REFERENCE: Arborist Response to 1st Review & RFI
Trees 4 & 5

SITE ADDRESS: 2825 West Mercer Way, Mercer Island WA

DATE: April 30, 2021

PRELIMINARY TREE RETENTION AND REPLACEMENT PLAN
2825 W MERCER WAY
PRELIMINARY PLAT
 PARCEL #2174502425
 CITY OF MERCER ISLAND WASHINGTON

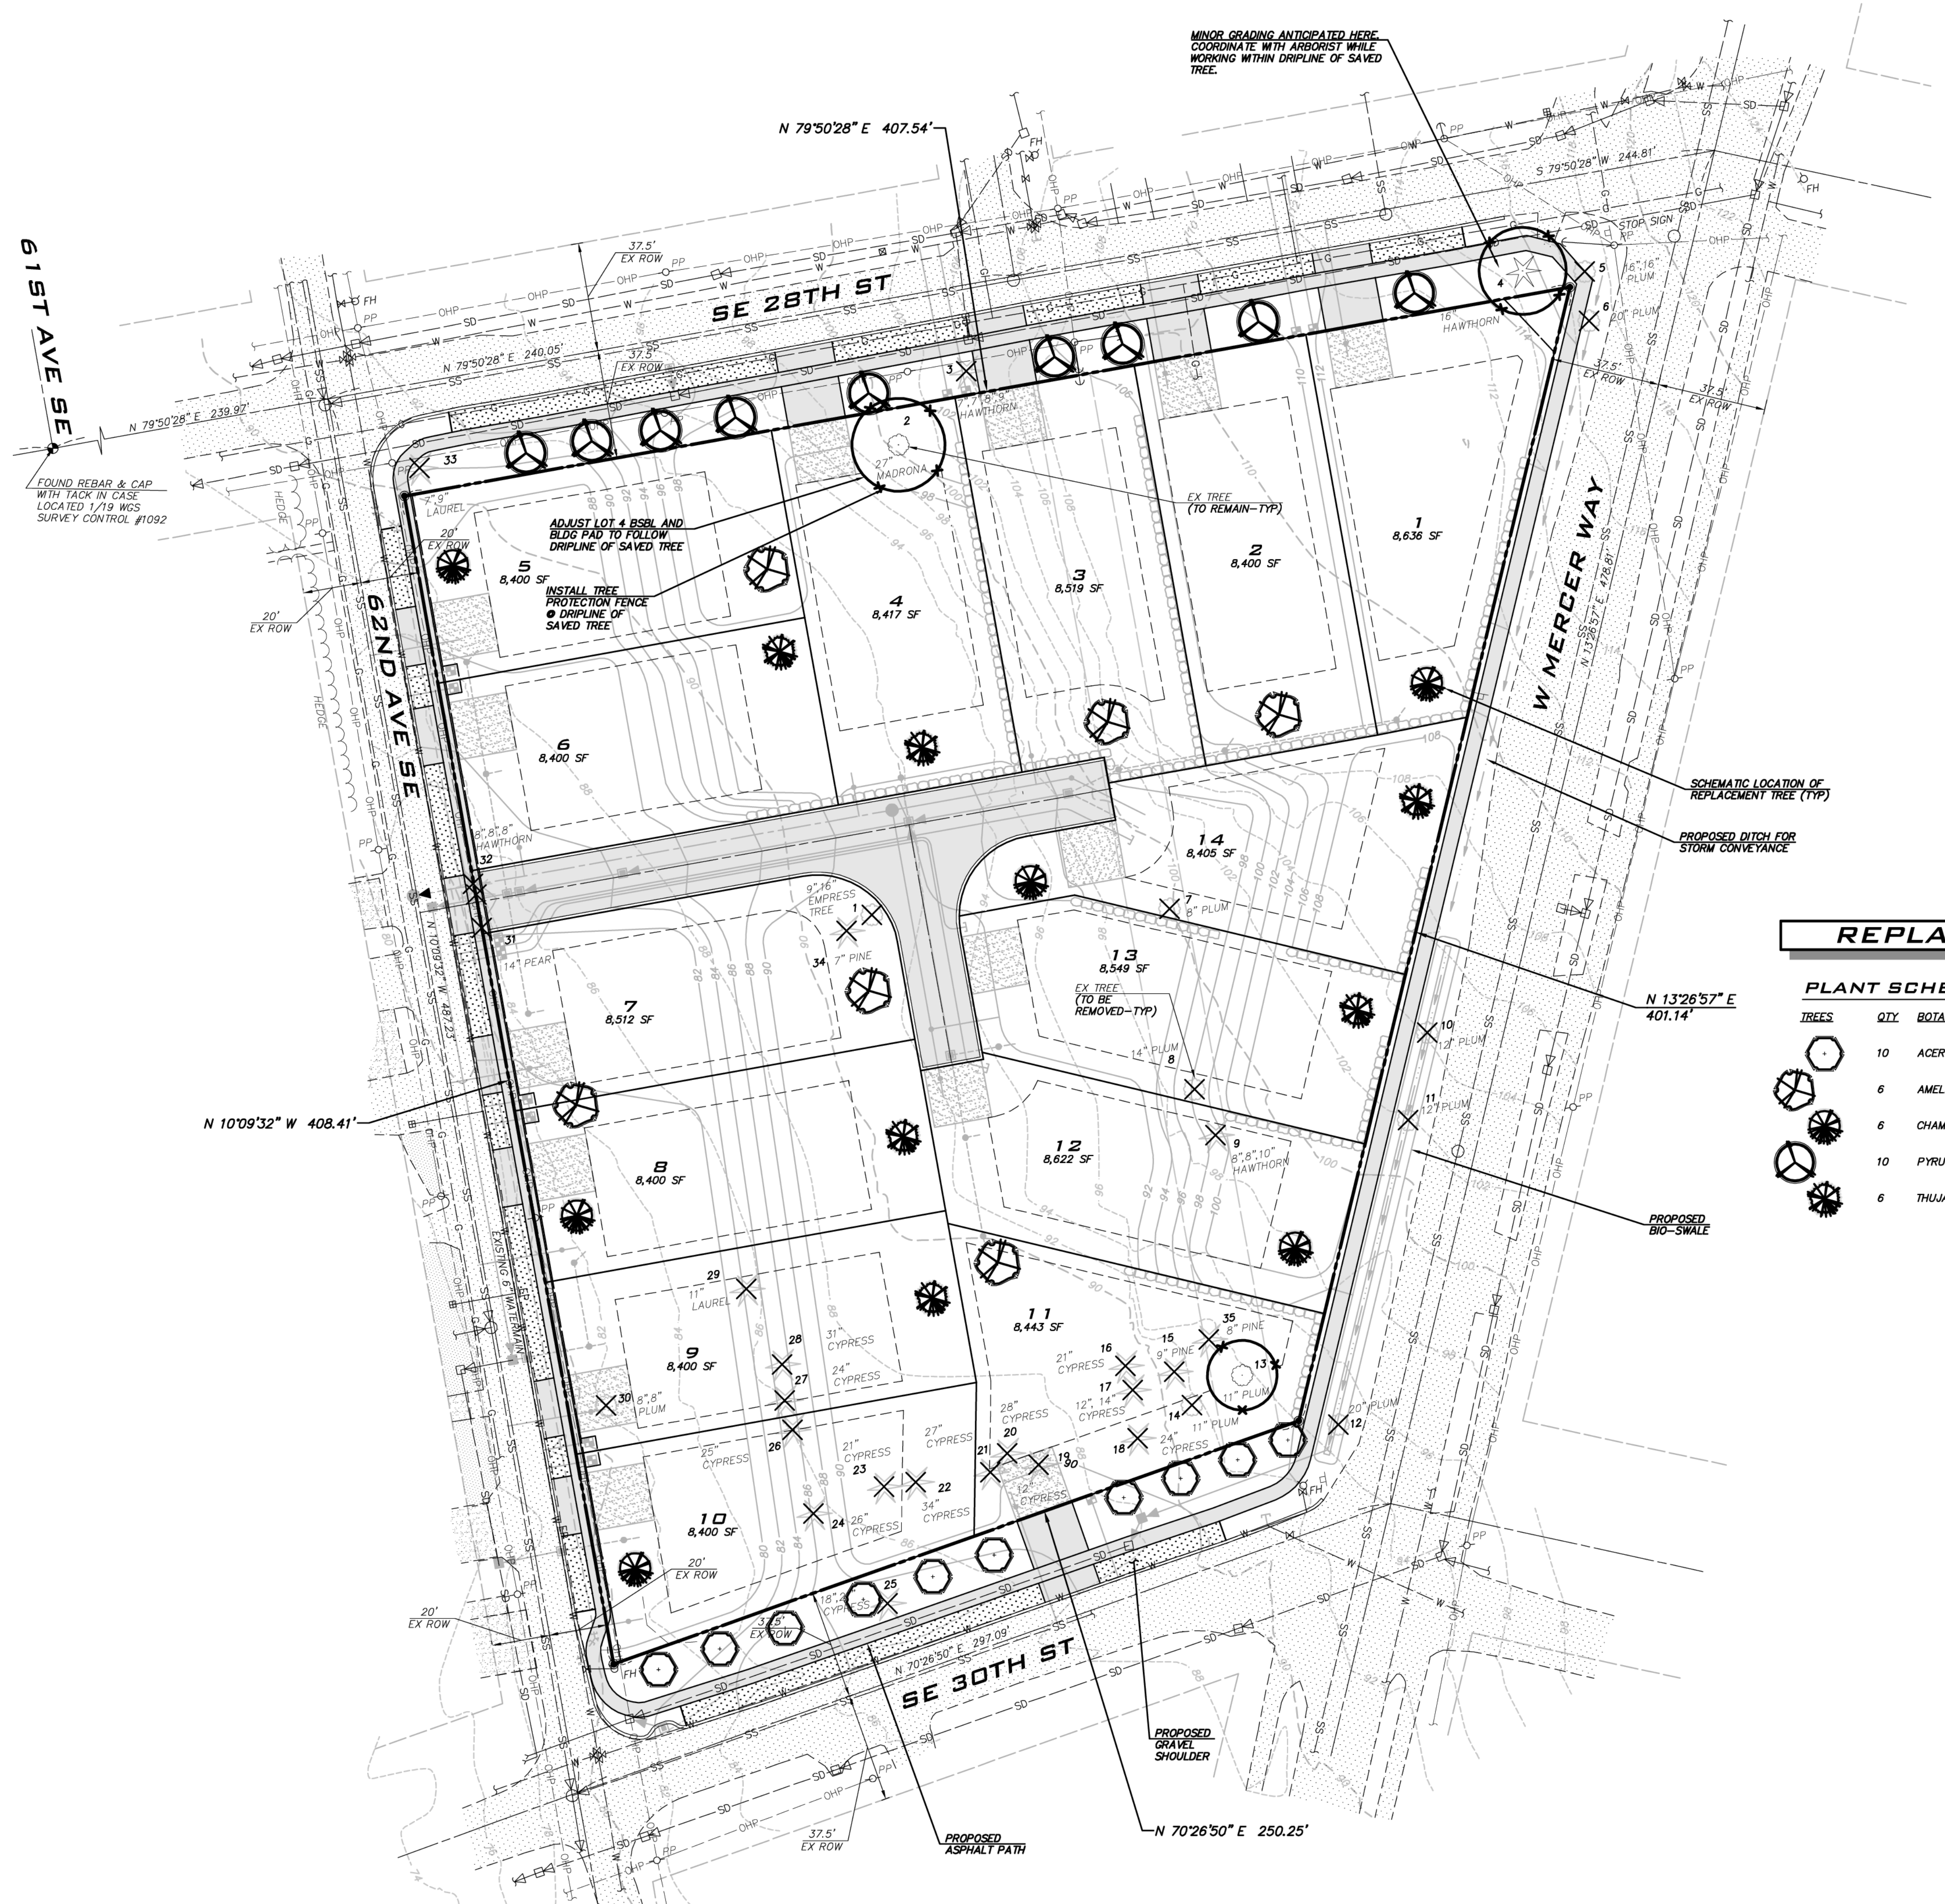
This memo is response to item 1, bullet 4: *Trees #4 and #5 are exceptional by size, but determined to be non-viable. Have your project arborist assess the trees for risk and likelihood of longevity.*

Both trees are over mature, and have visible branch dieback in their upper canopies, particularly tree 5. Below are images taken today. Dead branches throughout the canopy of tree 5 are copious and easily visible.

Tree 4 shown below, the hawthorn, also has dieback throughout the canopy. It, too, has begun a decline that in my opinion will continue until it too is too unsightly to ignore.

Additionally, this tree species is on the King County Noxious Weed list, and although it appears healthy a green with its new foliage today, by the end of summer, a fungal blight will defoliate tree.

The overall risk rating for each tree is low. Both trees are so small that they have a relatively short fall distance, and (future) targets with this distance (40') will include vehicles, primarily, and possibly pedestrians, rather than the proposed new residences.

Both trees have begun a process of decline from which they will not recover; an inevitable part the overall senescence of a tree.

It is my opinion that this **plum tree** has no remaining useful life as a landscape amenity. The vast majority of its branches are dead. The tree is unsightly, and will likely die standing.

The hawthorn, though appearing healthy today, has 10 or fewer years of useful life.

I recommend that no effort be made to retain trees 4 &5, and that they be removed.
